**From:** Planning  
**Subject:** FW: Planning Application Comments - 3/2023/0866 FS-Case-582779234

**Planning Application Reference No.:** 3/2023/0866

**Address of Development:** 11 Old Road, Chatburn

Proposed Site Plan 1:200

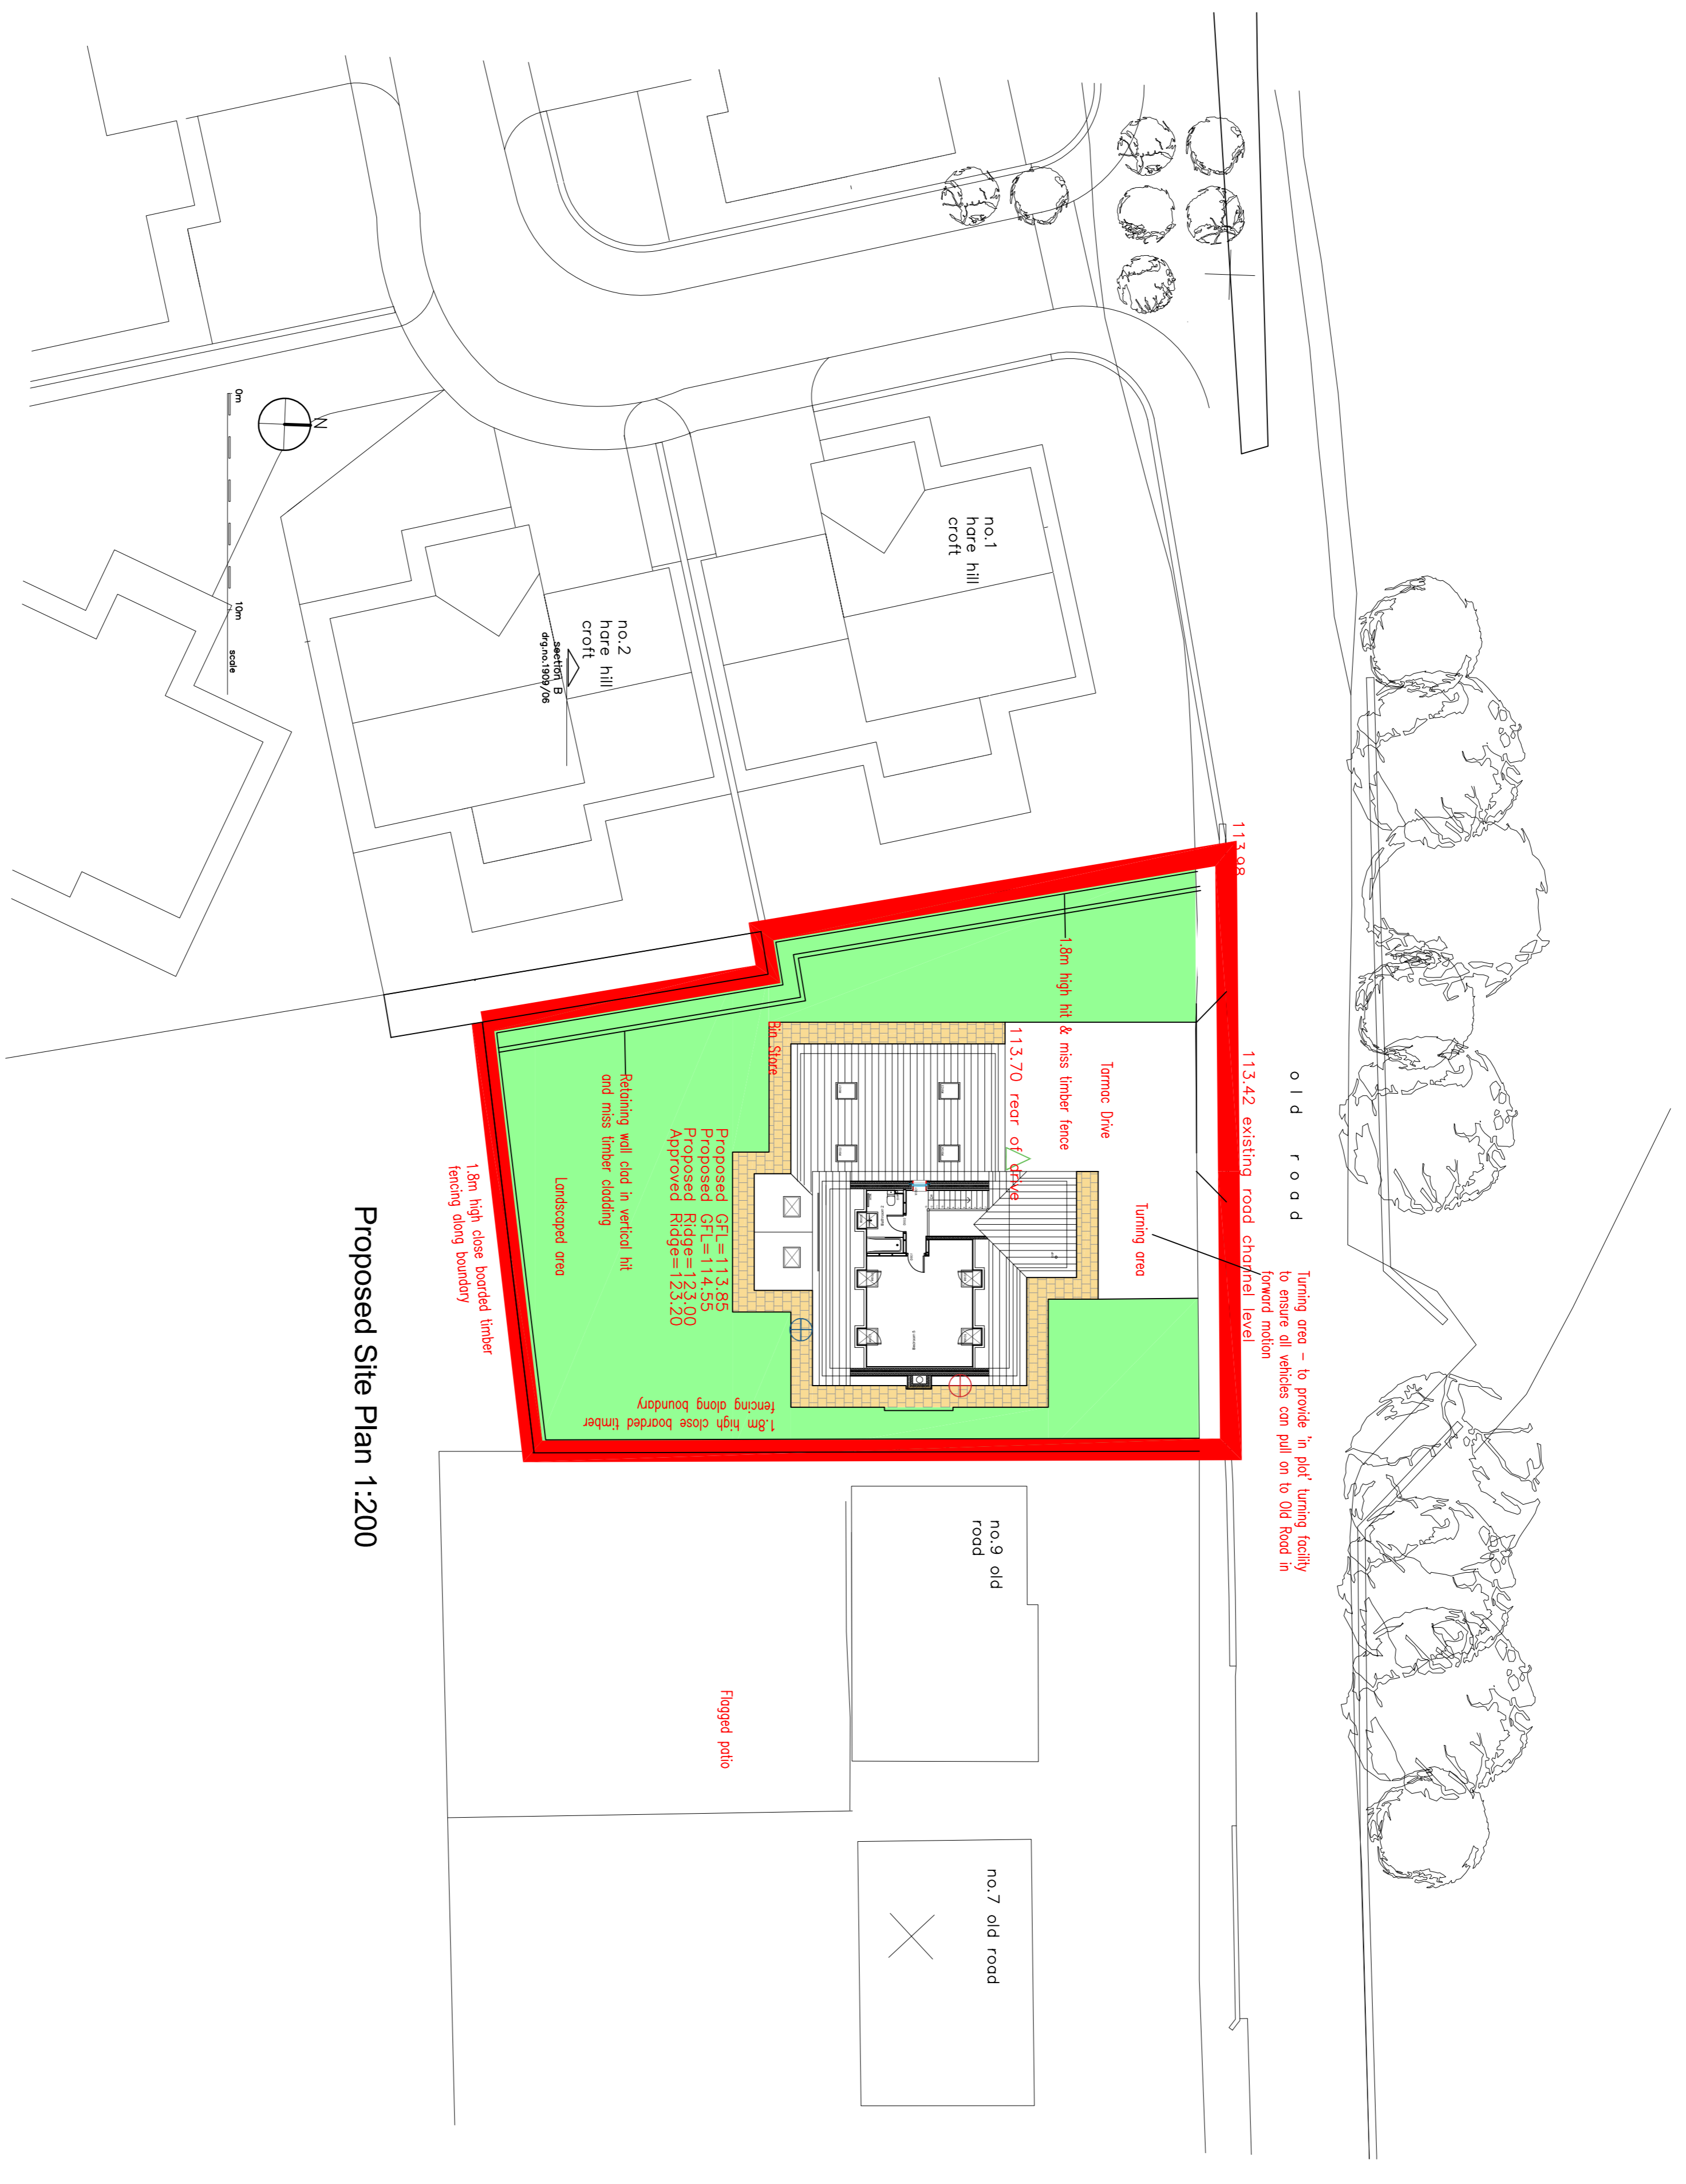
**Comments:** Looking at the submitted drawings Top\_Survey\_29jan24 and comparing to Proposed\_Site\_Plan\_jan24, there seems to be a significant difference in the orientation of the proposed house. Both plans show the house to be out of alignment with the other properties and with Old Road itself. However the alignment of the house is different in each drawing. Which is correct?
